Attachment A

JBA Section Reference	Item	Comments	Condition
2.1	Owners Consent	Objection	<p>COMPLIANCE WITH VOLUNTARY PLANNING AGREEMENT</p> <p>The development must be carried out in accordance with the obligations of the Voluntary Planning Agreement executed on date between the City of Sydney, Tristar Sandstone Pty Limited and Properties NSW.</p>

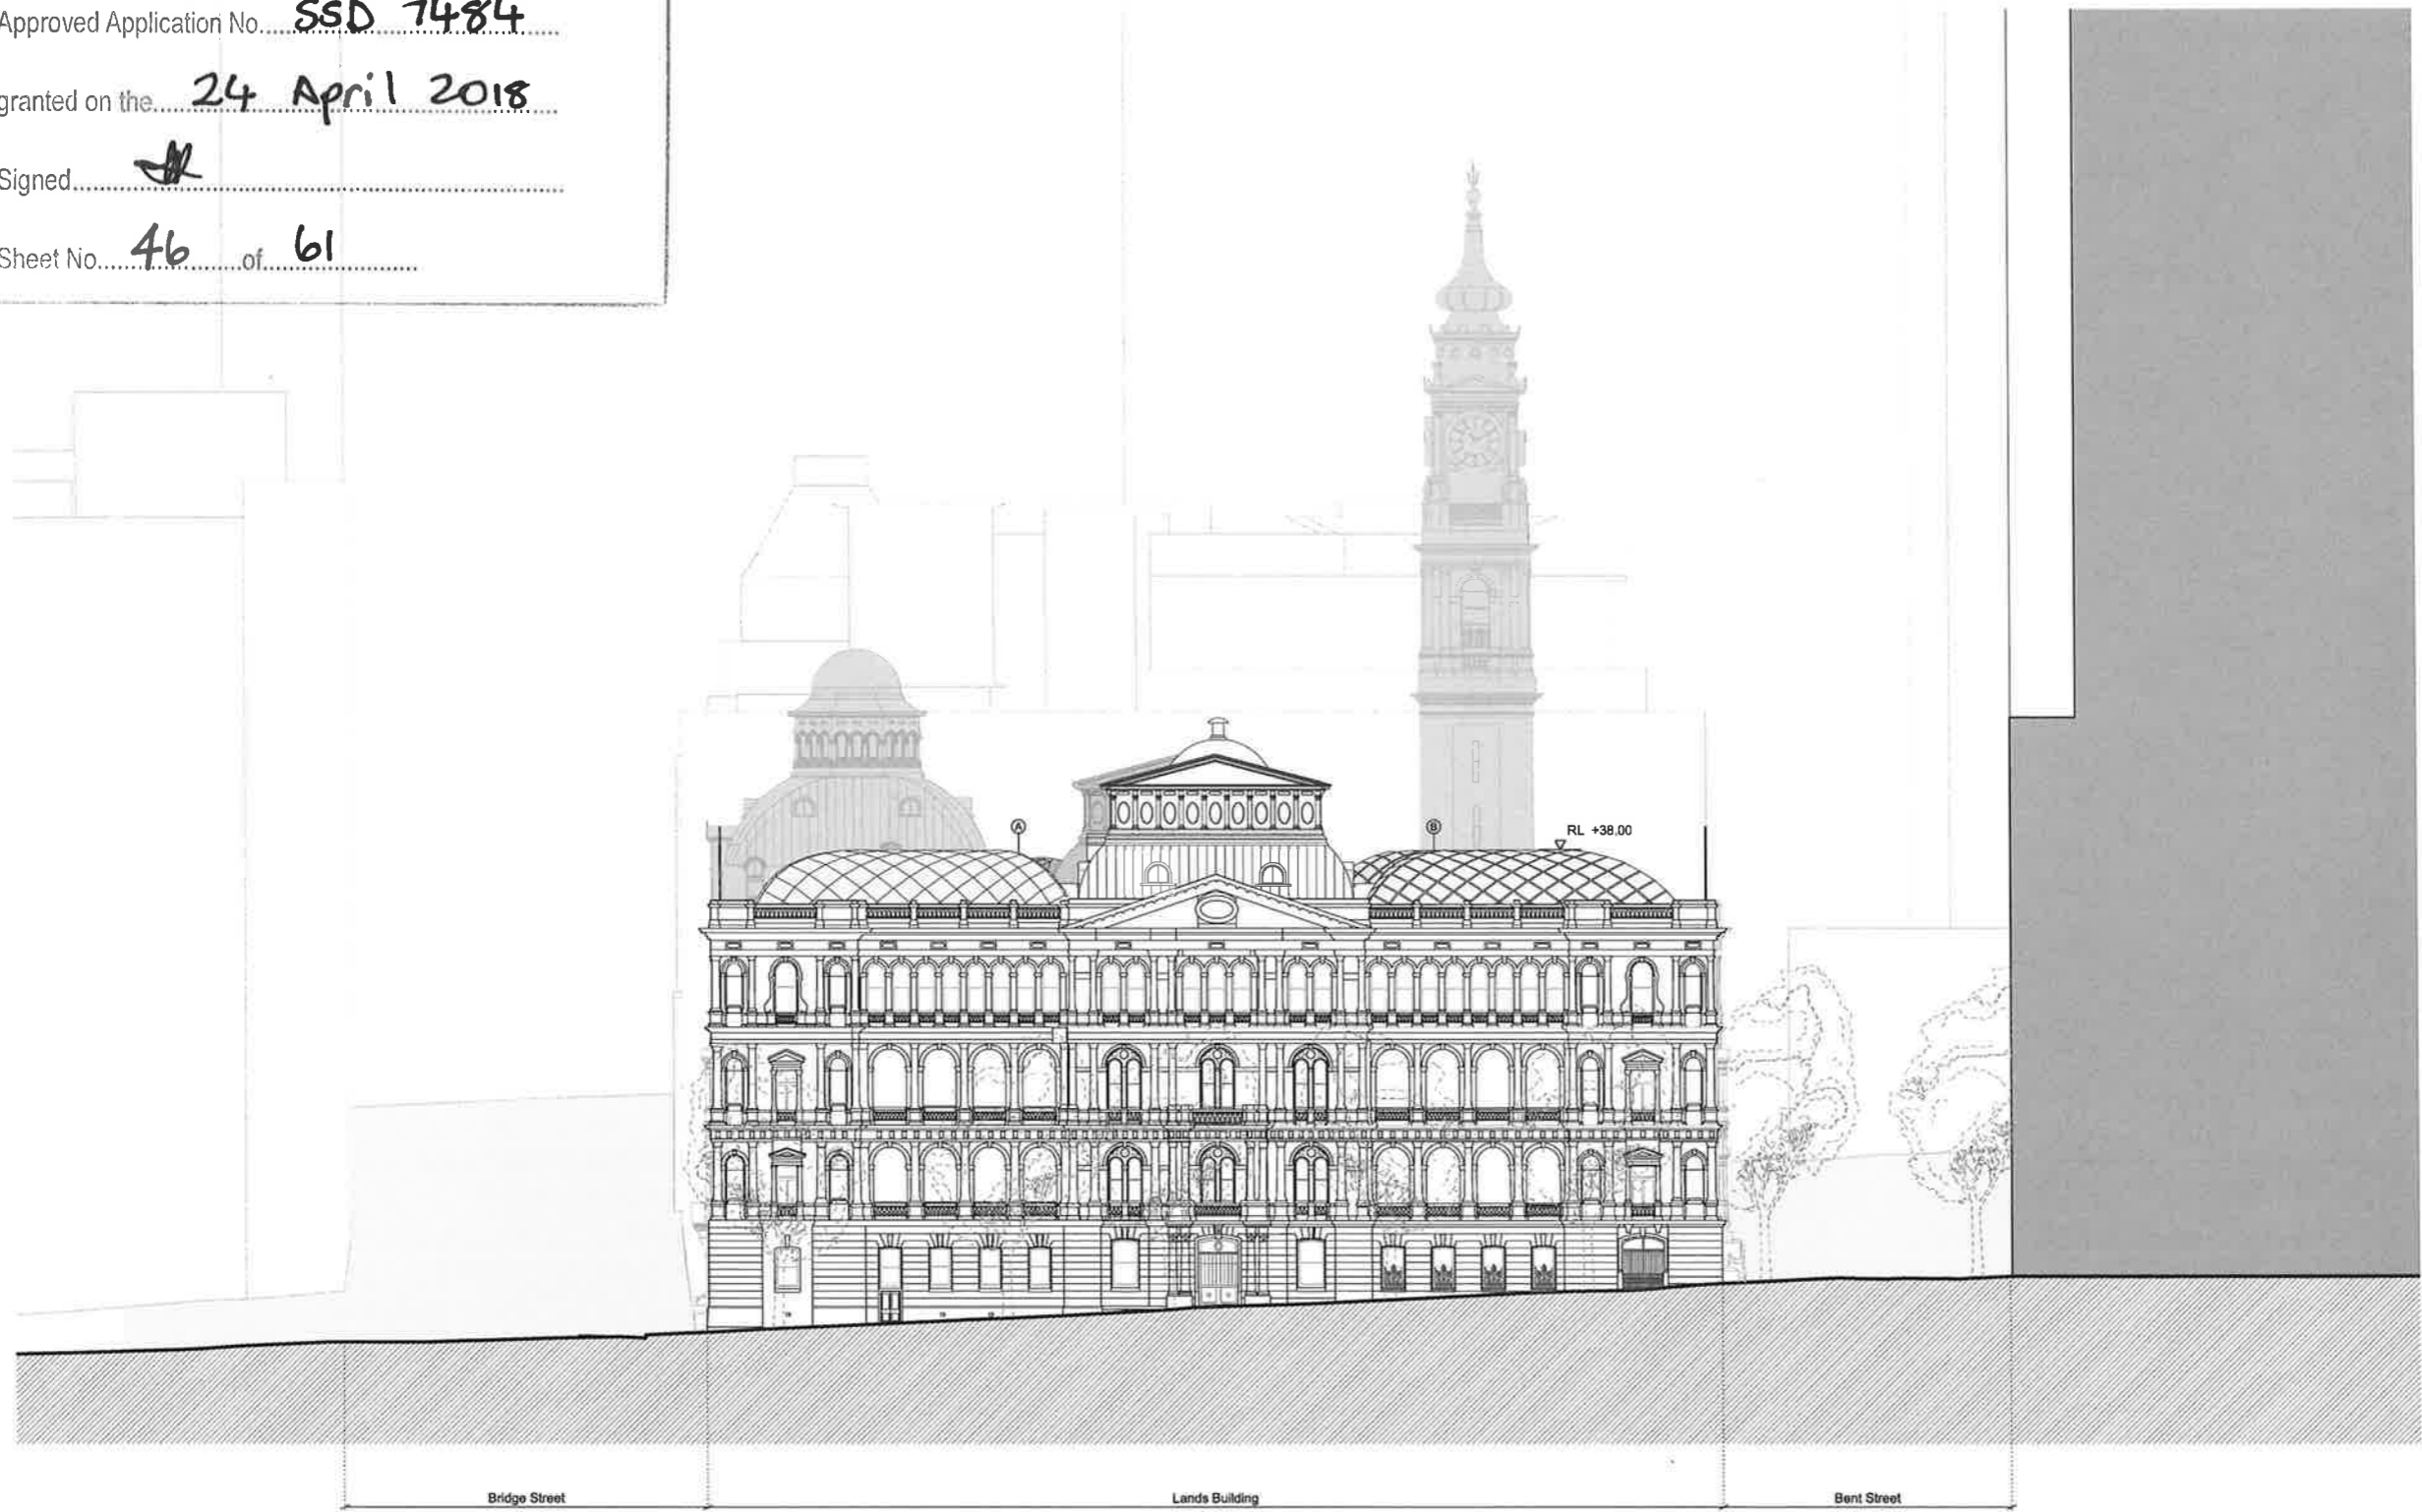
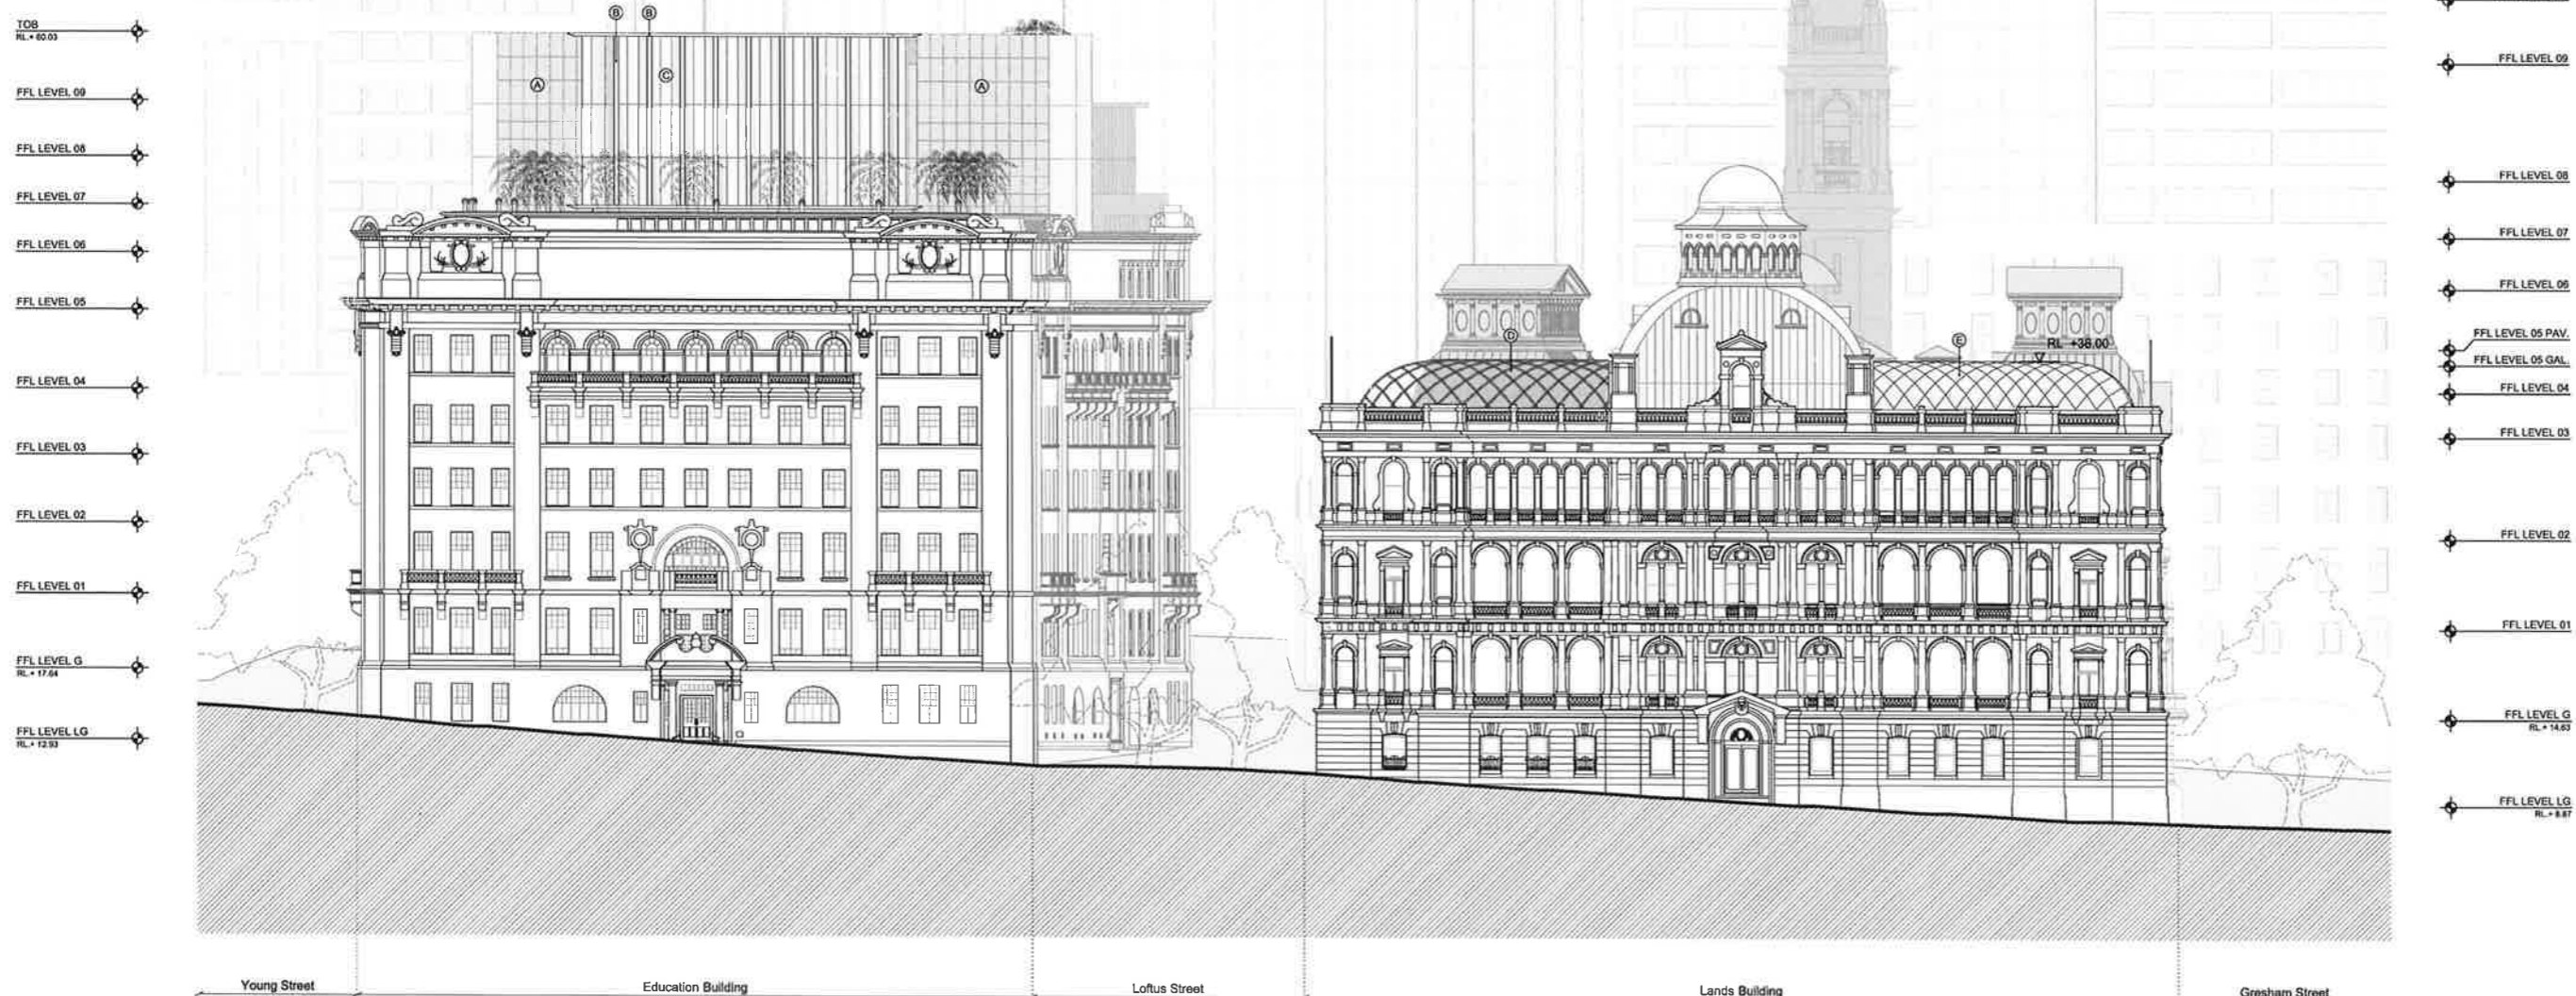
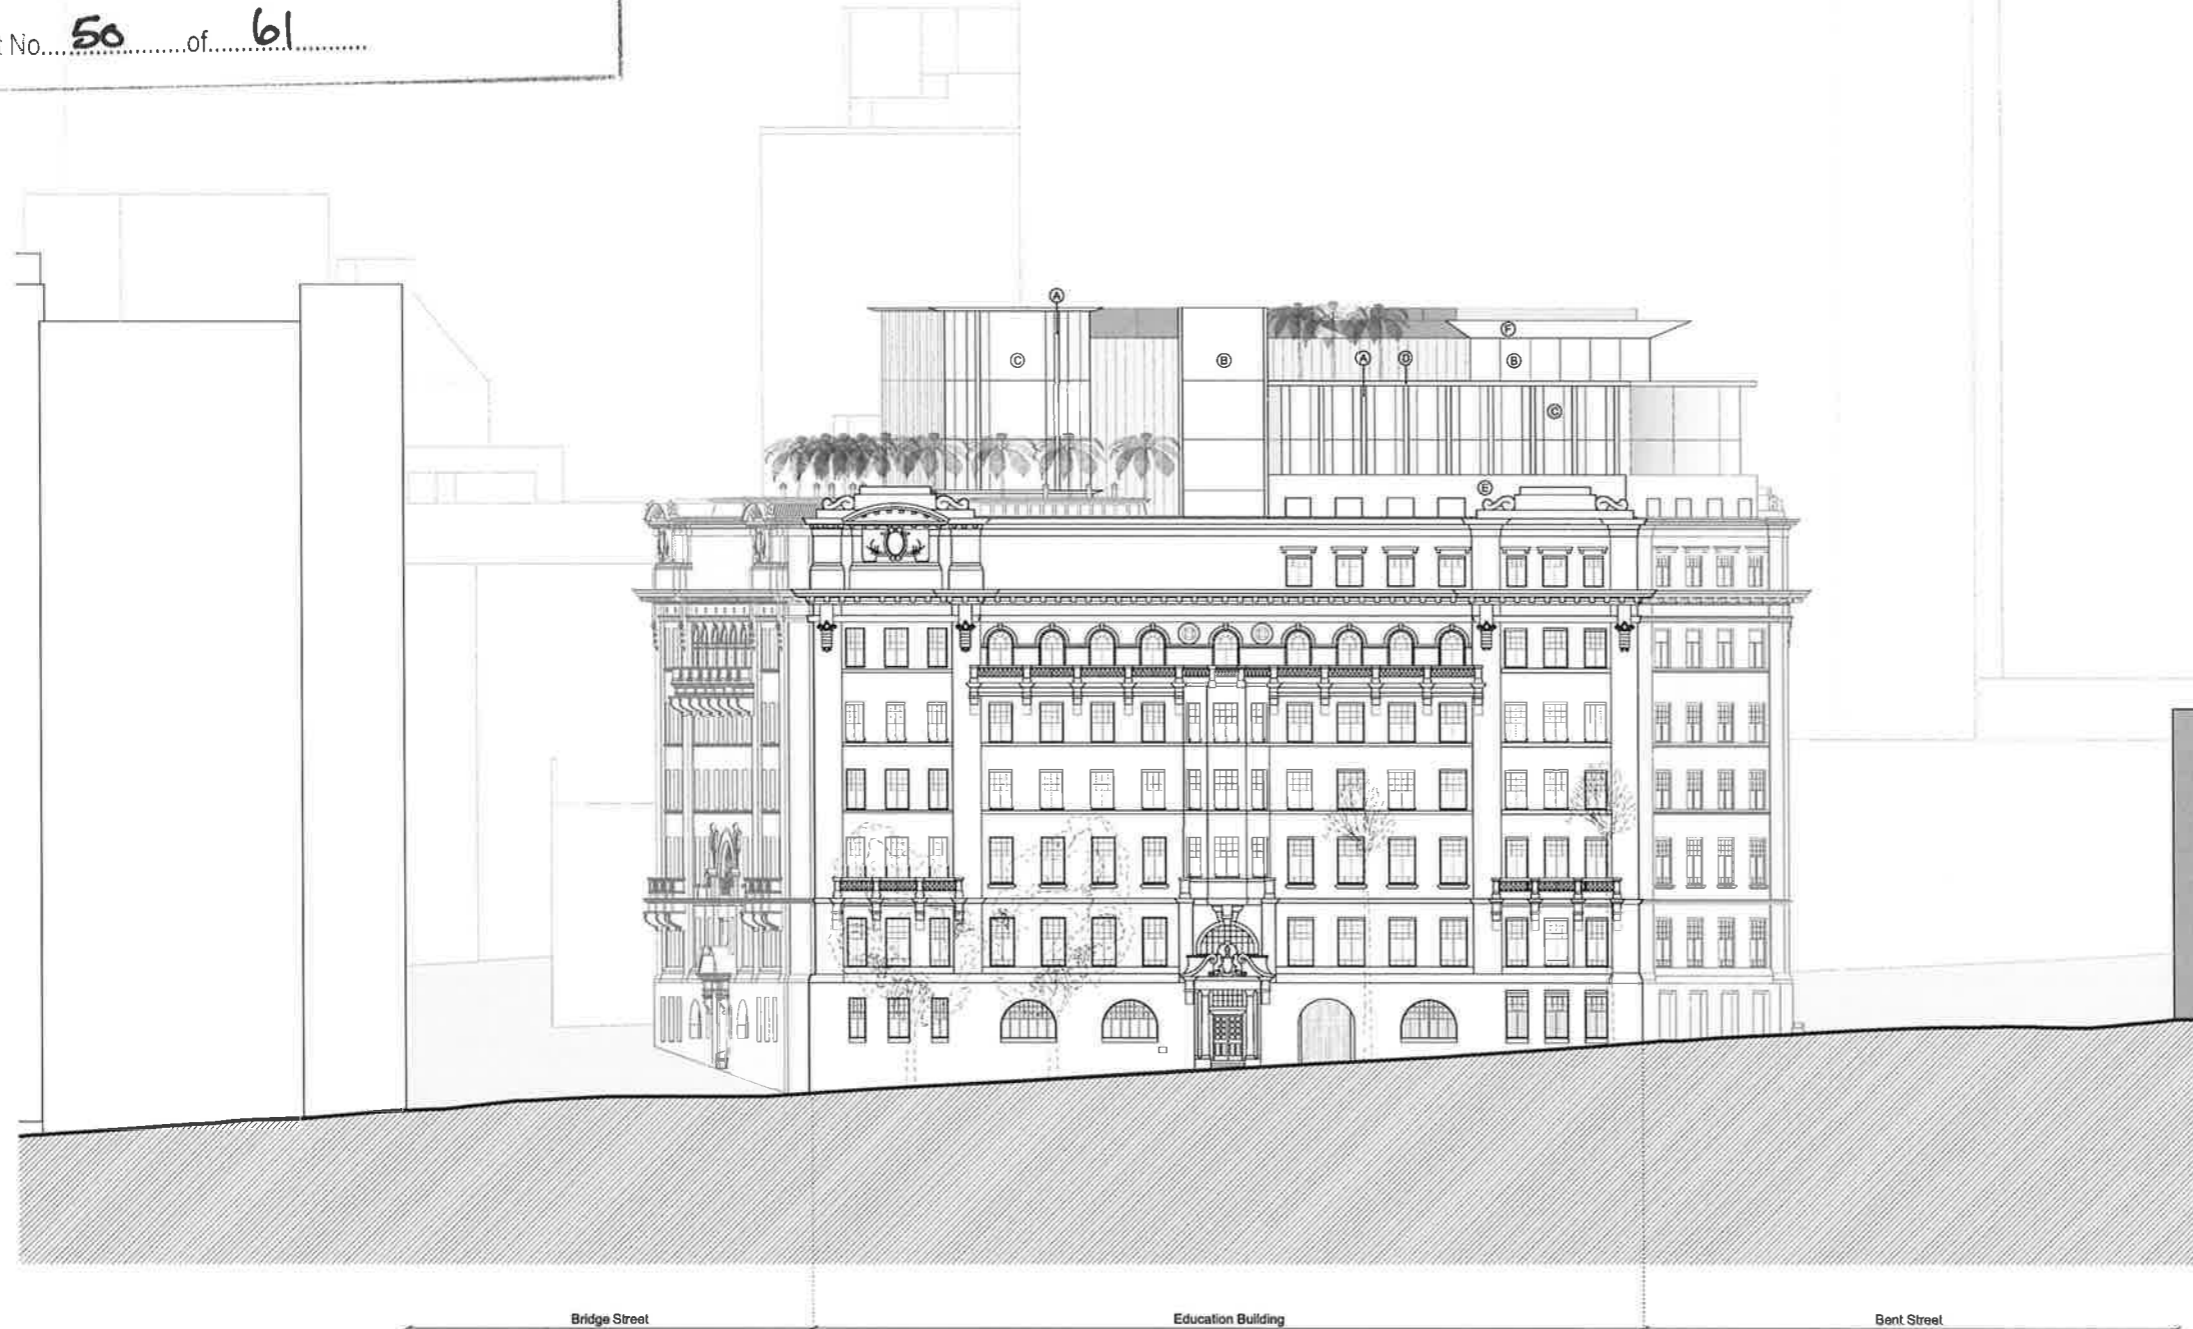
3.2.14	Roof Top Addition	Condition Recommended	<p>DESIGN DEVELOPMENT OF FACADES TO THE ADDITION OF THE EDUCATION BUILDING</p> <p>The design development for the Education Building is to ensure that the curved glass bays remain and are not modified to a faceted form. Prototypes are to be constructed for approval prior to issue of Construction Certificate 3 - Structure.</p>
